December 7, 2010

RE: Harnett County Land Use Existing Tank Application #10-5-25669

The Harnett County Department of Public Health, Environmental Health Division on December 6, 2010, evaluated the above referenced property at the site designated on the plat/site plan that accompanied your existing tank application. According to your application requesting a 24 x 24 detached garage/shop the evaluation was done in accordance with the laws and rules governing wastewater systems in North Carolina General Statute 18A.1950 including related statutes and Title 15A, Subchapter 18A, of the North Carolina Administrative Code, Rule.1950 and related rules.

Scale 1" = 40'

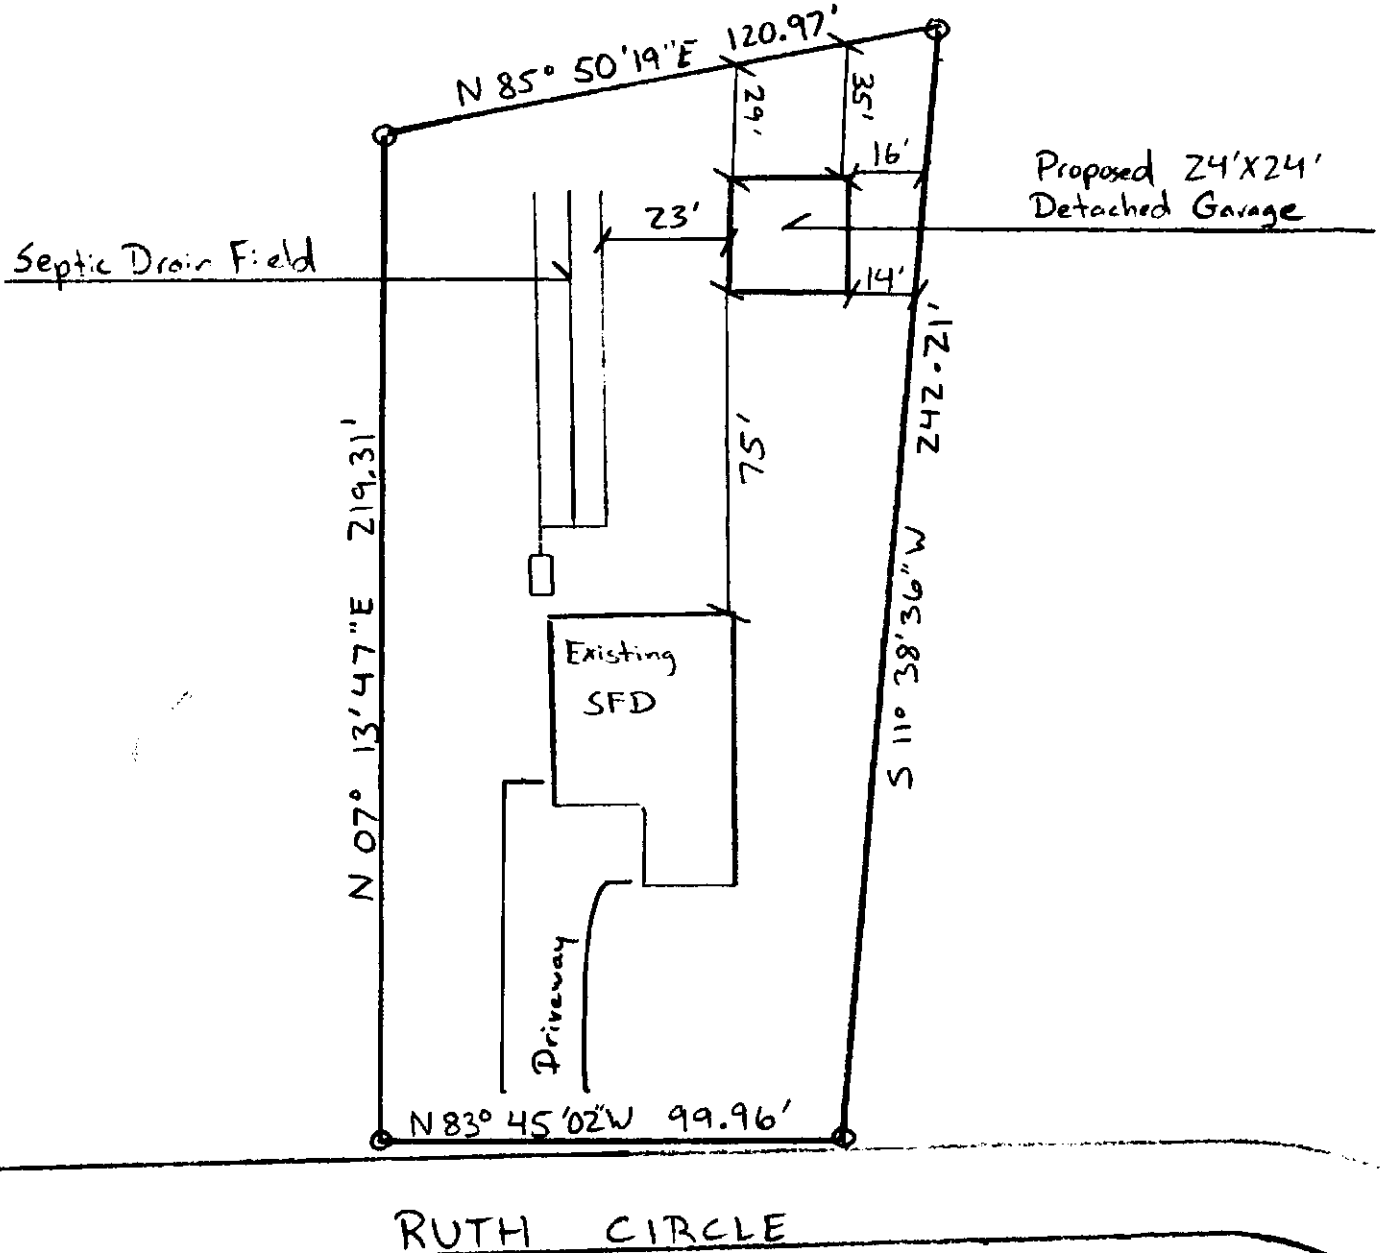
Based on the criteria set out in Title 15A, Subchapter 18A, of the North Carolina Administrative Code, Rules .1950, the evaluation indicated that the site is **UNSUITABLE** for the addition requested. Therefore, your request for an existing tank is **DENIED**. The site is denied based on the following:

X 15A NCAC 18.1945{b} - Each lot shall have original septic system plus repair area.

**Your proposed building will be on your repair area.*
